Town & Country Planning Act 1990 (as amended)
Town & Country Planning (General Permitted Development) Order 2015 Schedule 2, Part 16

Application No: LU/154/22/TEL
Site Address: Land at junction of Hollyhock Way and Worthing Road Littlehampton BN17 6SH
Description of works: Prior Notification under Schedule 2 Part 16 Class A for a proposed 5G telecoms installation: H3G Phase 8 high street pole c/w wrap-around cabinet: and 3 further additional equipment cabinets.

Thank you for your internet representation made on 18th July 2022 which has been recorded as an objection with the comments as follows:

215 PROPOSED SITE PLAN

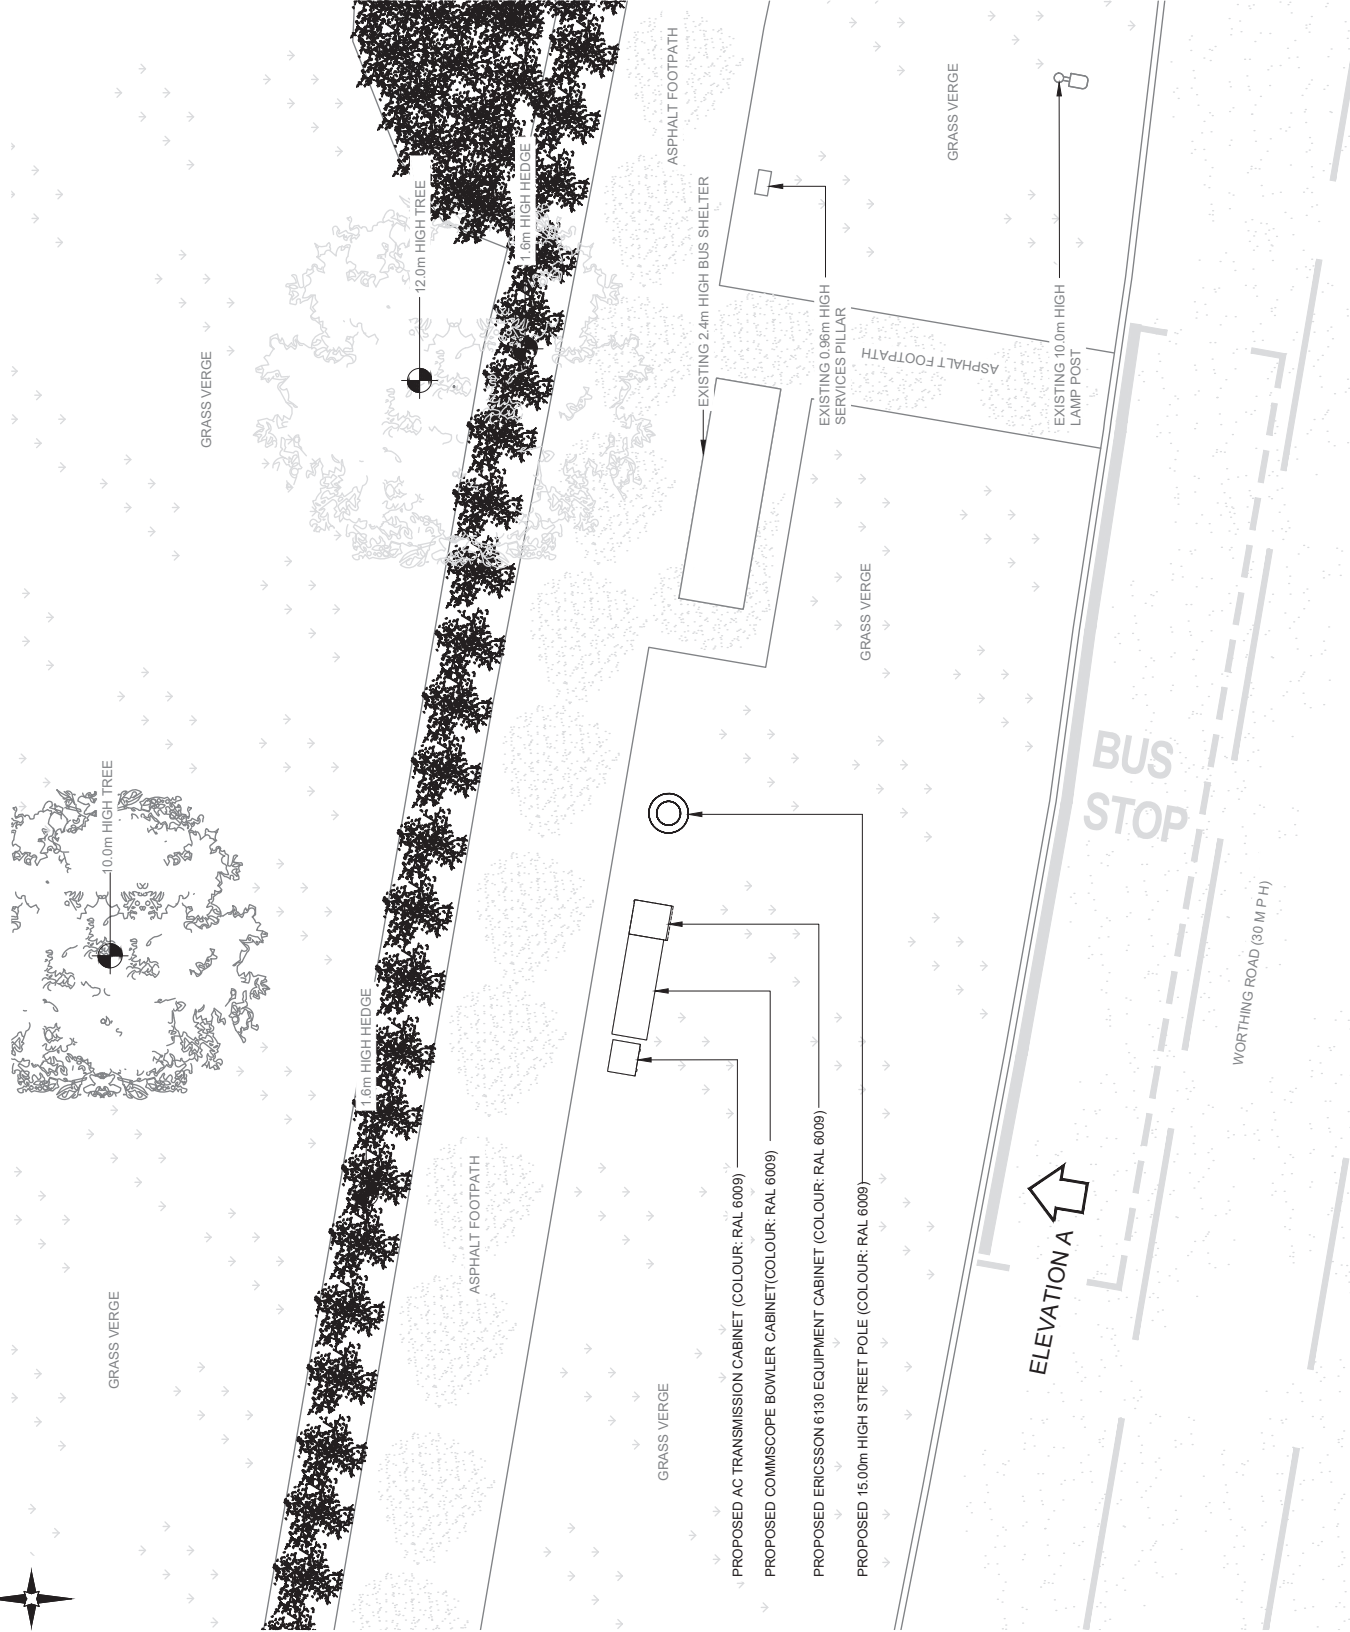
3. There will be a material impact on the highway landscape and a development such as this is not compatible with a road in a residential area. In addition it will affect the site line for vehicles exiting Hollyhock Way and also the site for passengers sitting in Athena bus shelter.

5. The cabinets will be a boon to graffiti artists and vandals - witness the damage frequently done to the bus shelter - thus causing an environmental eyesore and doing nothing to enhance the area.

Title: **265 PROPOSED SITE ELEVATION**

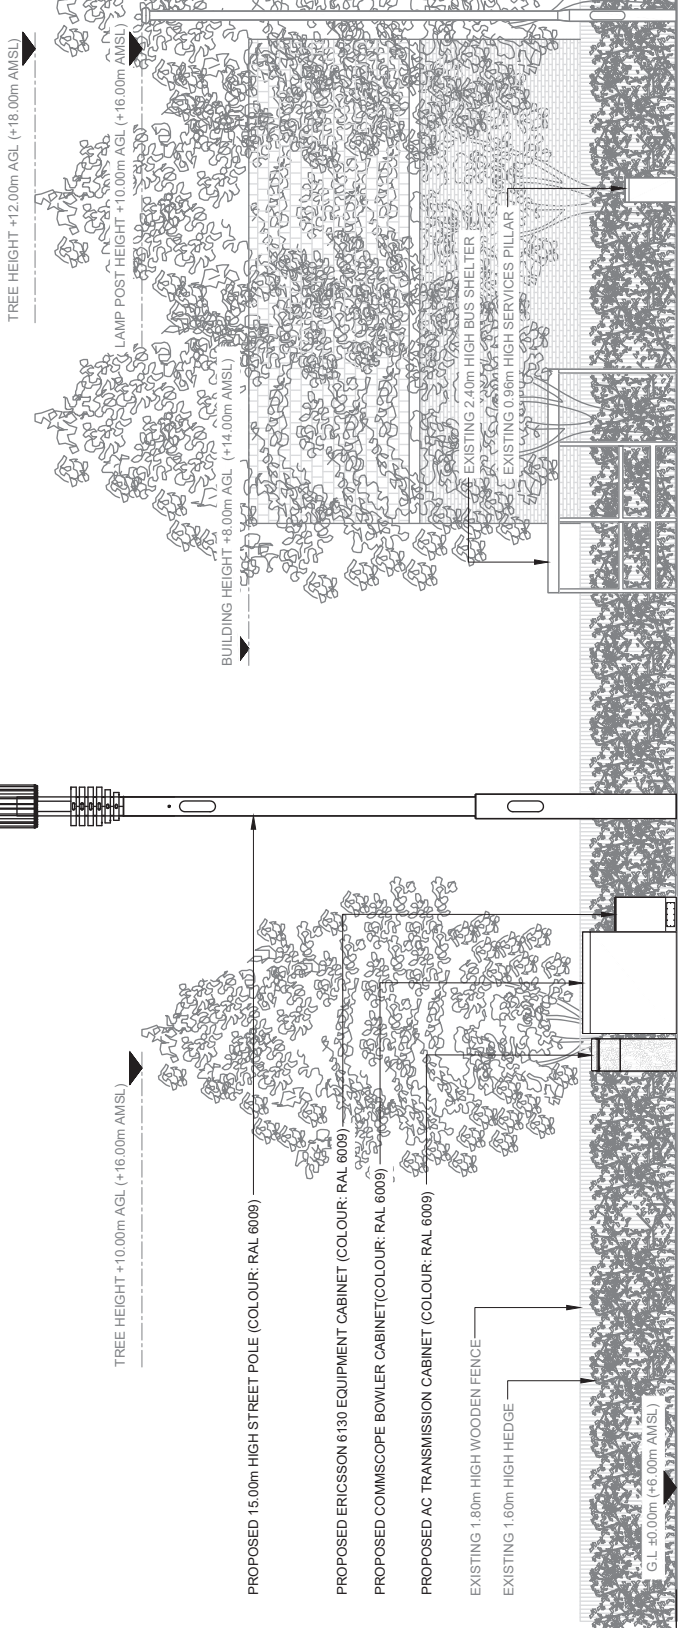
1. The mast is in too close proximity to residential dwellings. It is generally accepted that a mast should be at least 75 m from any dwellings to obviate any health and environmental concerns. This is clearly not the case here and the development will blight our properties.
